From: Martyn White
Sent: 10 January 2013 11:44
To: Planningecons
Cc: Katherine Rawlins
Subject: AW/238/12/

Application Number	AW/238/12/
Address	49 The Drive
Description	Change surface finish of drive and path
Case Officer	Miss K Rawlins

SITE LOCATION PLAN
AREA 2 HA
SCALE 1:1250

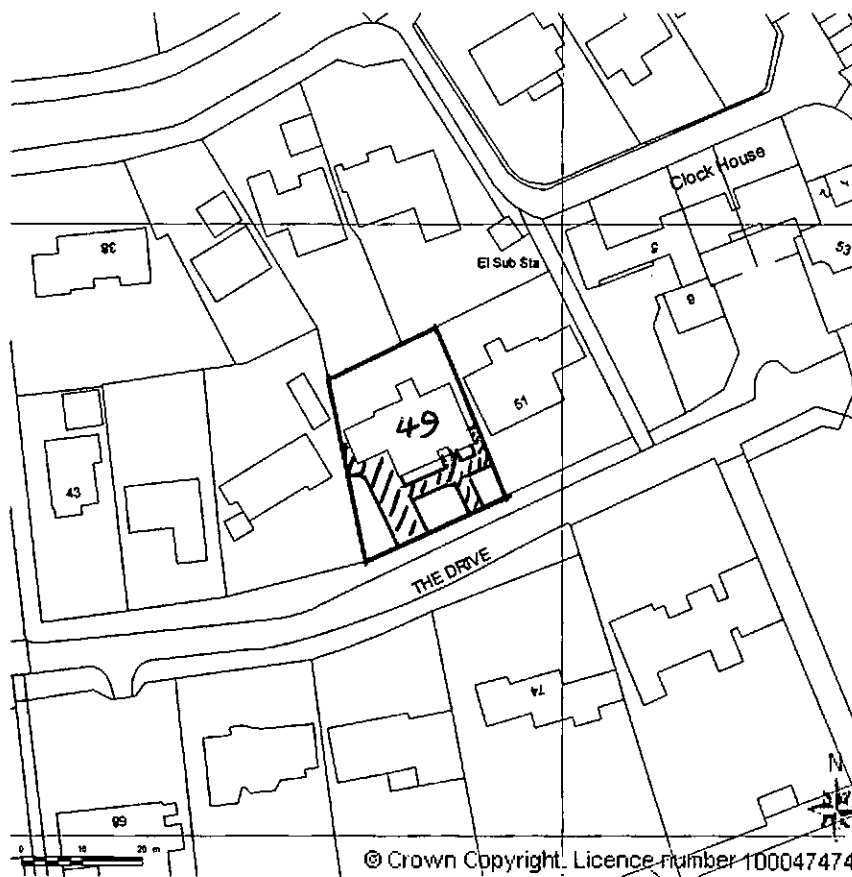
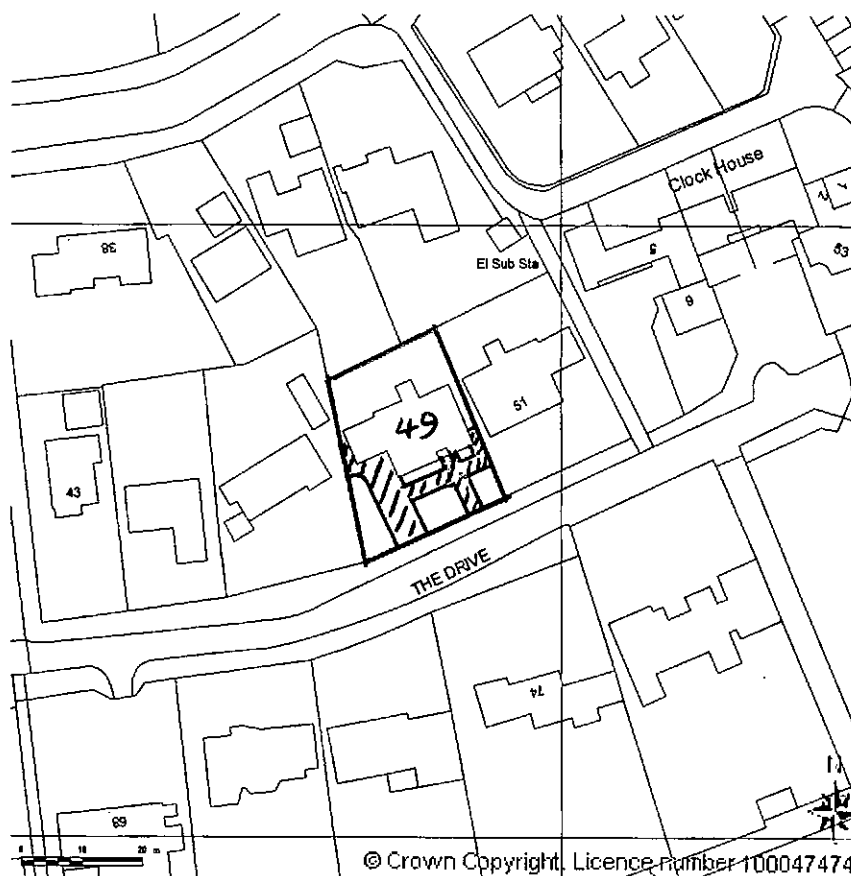
The proposal is for a replacement surface material to an area which provides both driveway and pedestrian access. I note that the area to be covered is exactly the same as that covered by the existing material. The area is fairly substantial and any proposal will potentially have an impact on the locality.

The carriage way material consists of roll top tarmac which is very dark. This helps to define the public from the private. However, saying that, the various private driveways are, in some circumstances, fairly dark. The proposed paving material would in this context not be too obtrusive.

Is it possible to confirm the material to be used; is it slate or a material dressed to look as though it is slate?

However, as the proposal currently stands, it does not enhance the conservation area, but it can't really be said to detract from it either.
